**KIRKLEES METROPOLITAN COUNCIL
INVESTMENT & REGENERATION SERVICE**

DELEGATED DECISION TO DETERMINE PLANNING APPLICATIONS

Reference No: 2022/61/90097/W

Description: Reserved matters application pursuant to outline
permission 2021/93779 for erection of residential
development with parking and private landscaped
gardens

SECOND FLOOR

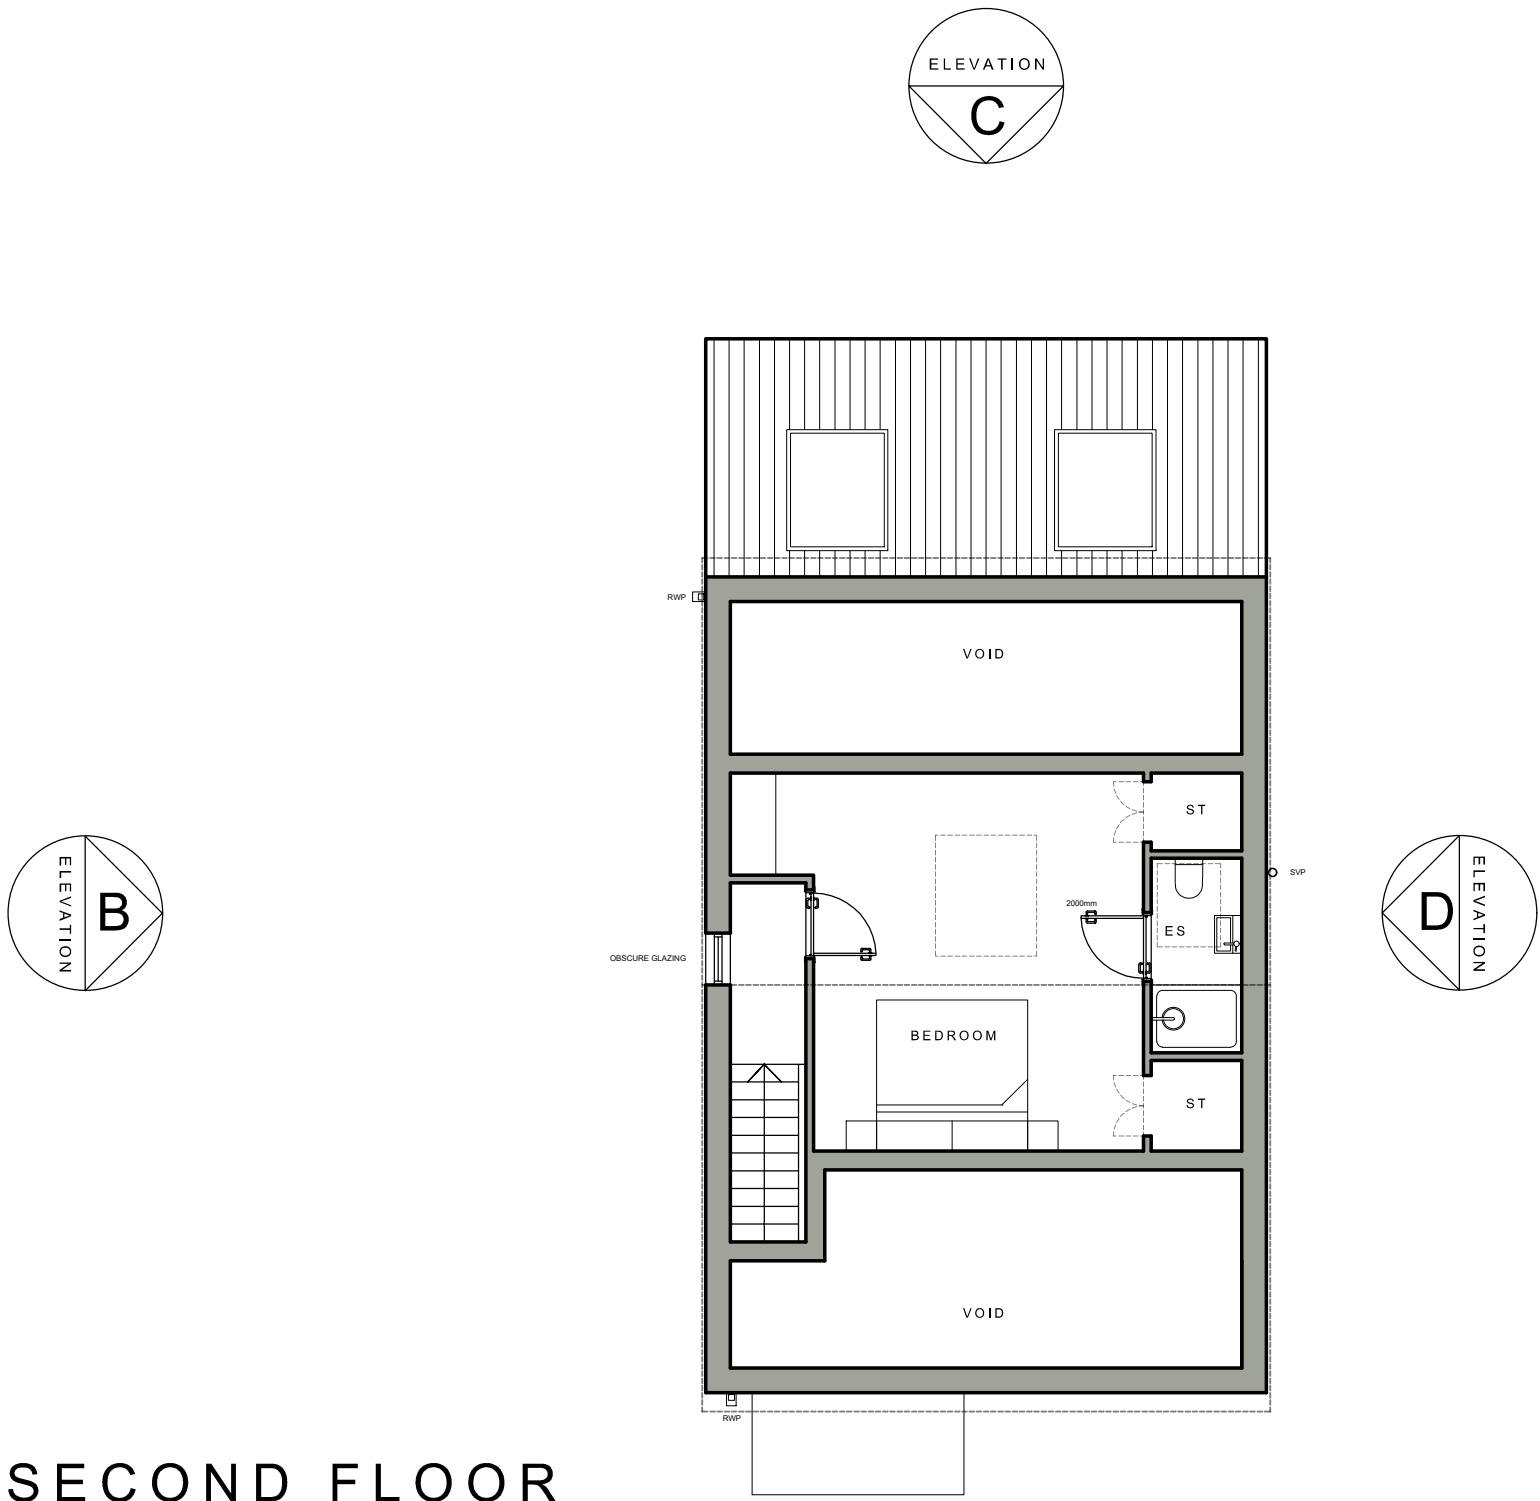
The case officer sought amendments to reduce the height of the proposed dwelling, so that it aligned with the eaves height of the neighbouring property to the south east (No. 134 Laund Road). In addition, the case officer sought amendments to the design of the proposed dwelling, seeking the removal of the originally proposed velux window to the front roof panel. Furthermore, the case officer requested that all of the proposed glazing be obscured to the side elevations of the dwellinghouse.

The applicant also submitted Dwg no. 2245-D-20-110REVD, which shows all of the windows the side elevations of the dwelling, except one, to be obscurely glazed. The one left clear glazed is considered acceptable from a residential amenity perspective.

In terms of overlooking, all of the windows proposed to the side elevation facing towards this existing property will be obscurely glazed. Therefore, these windows present no detrimental potential of overlooking, in turn, preventing any significant loss to residential privacy.

There will also be no material overlooking, as any windows adjacent to the side elevation of No. 134 will be obscurely glazed. The proposed clear glazed window to the rear side elevation of the new property is adjacent to the detached garage structure within the curtilage of No. 134, therefore, considered to lead to no significant impact due to overlooking. It has also been noted that there is substantial boundary treatment in place along the south eastern boundary of No. 134, in the form of wooden fencing, this will further mitigate any potential loss of privacy.

The applicant successfully submitted amended plans which reflected the recommendations set out by the case officer. The applicant submitted Dwg no. 2245-D-20-111REVA, which appropriately shows the eaves height and maximum height of the proposed dwelling in line with neighbouring property No. 134 Laund Road. This drawing also demonstrated the removal of the front velux window.

4. All windows annotated 'obscure glazing' upon submitted drawing titled 'Proposed plans and elevations' ref:- 110RevD shall be obscure glazed minimum grade 4. The obscure glazing shall thereafter be retained for the lifetime of the development.

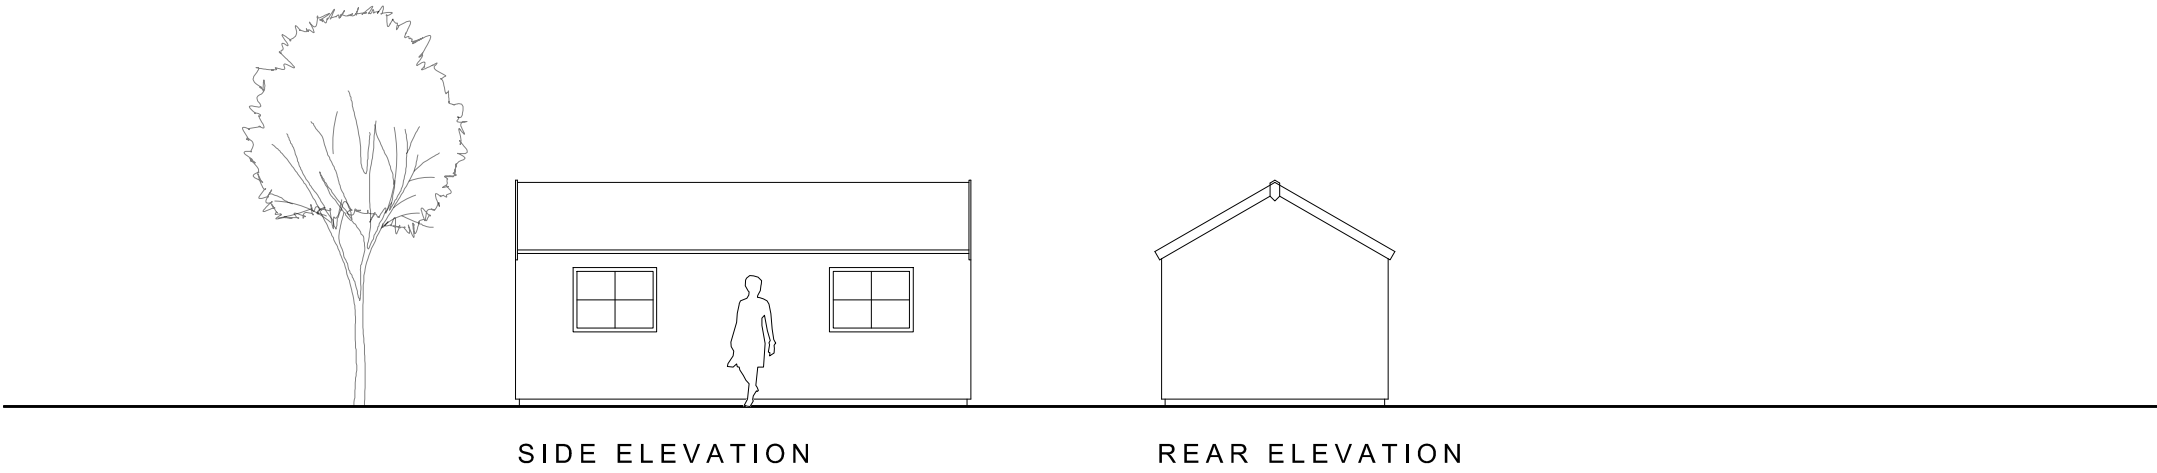
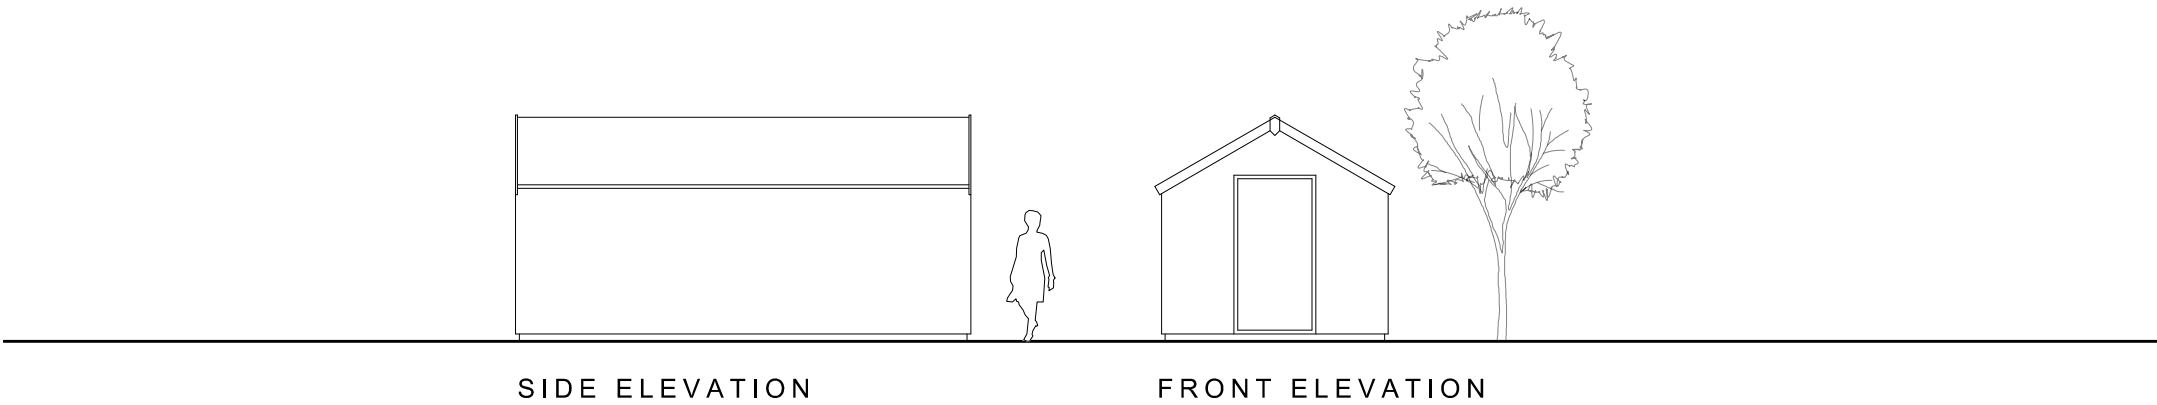
The case officer also requested that the applicant submit a plan to show the proposed elevations of the shed structure, as shown on the proposed site plan, Dwg no. 2245-D-20-102REVA. The applicant supplied Dwg no. 2245-D-20-112, which demonstrates the proposed size/scale of the shed structure, with regard to its length, width, height and style of construction.

In addition, the shed will be 6 metres in length, 3 metres in width and have a height of 2.9 metres. This size/scale, in conjunction with the proposed site of erection, will not create any significant impacts upon residential amenity with regard to overbearing or overshadowing.
